SSD 8665 MERCANTILE HOTEL - RTS

Please see our response below to DPE's Request for Further Information dated 7 June 2019 (initially sent via email on Thursday, 4 July 2019):

Figure 1 Ground Floor - Outdoor Dining Area

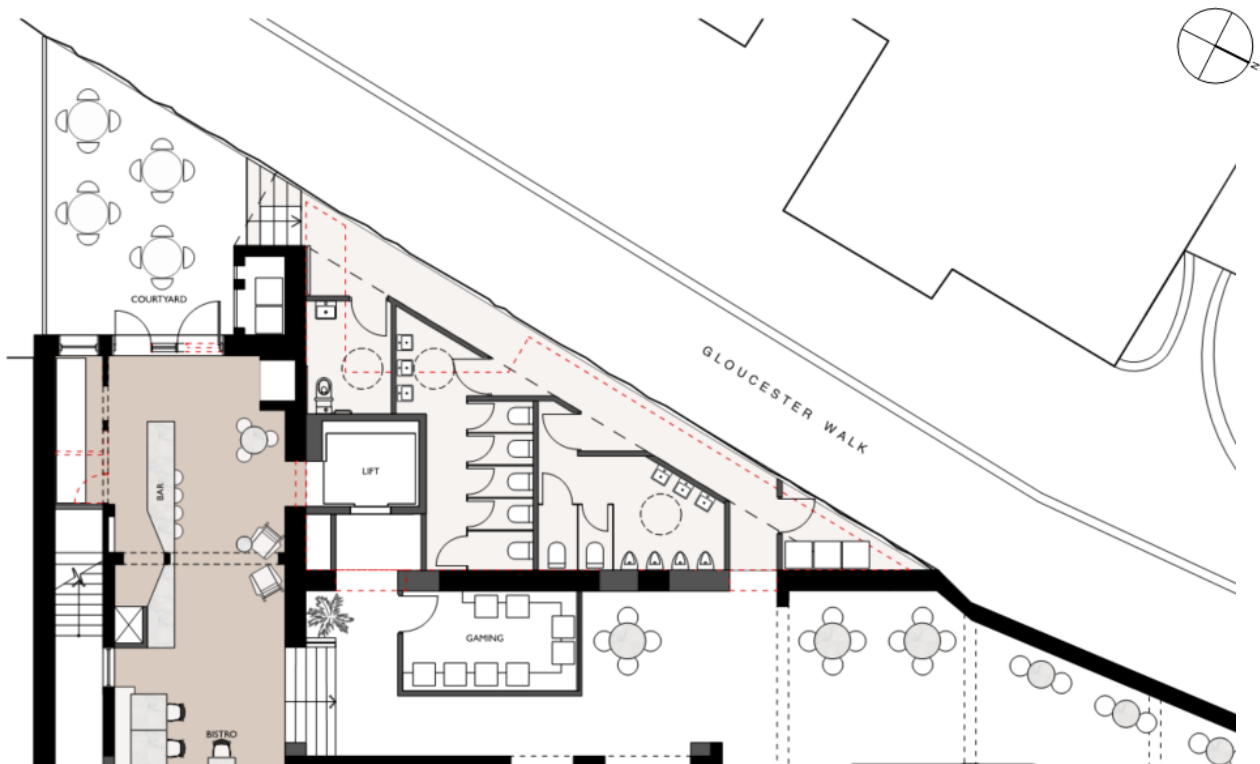
Confirm an allowance has been made in the Noise Assessment for noise impacts associated with the ground floor courtyard.

- Please refer to a letter prepared by SLR attached.
- The letter confirms the predicted noise level when the courtyard is at full capacity (16 people) is 43 dBA, which is not expected to contribute to the overall venue noise emissions at nearby sensitive receptors. No further assessment is required.
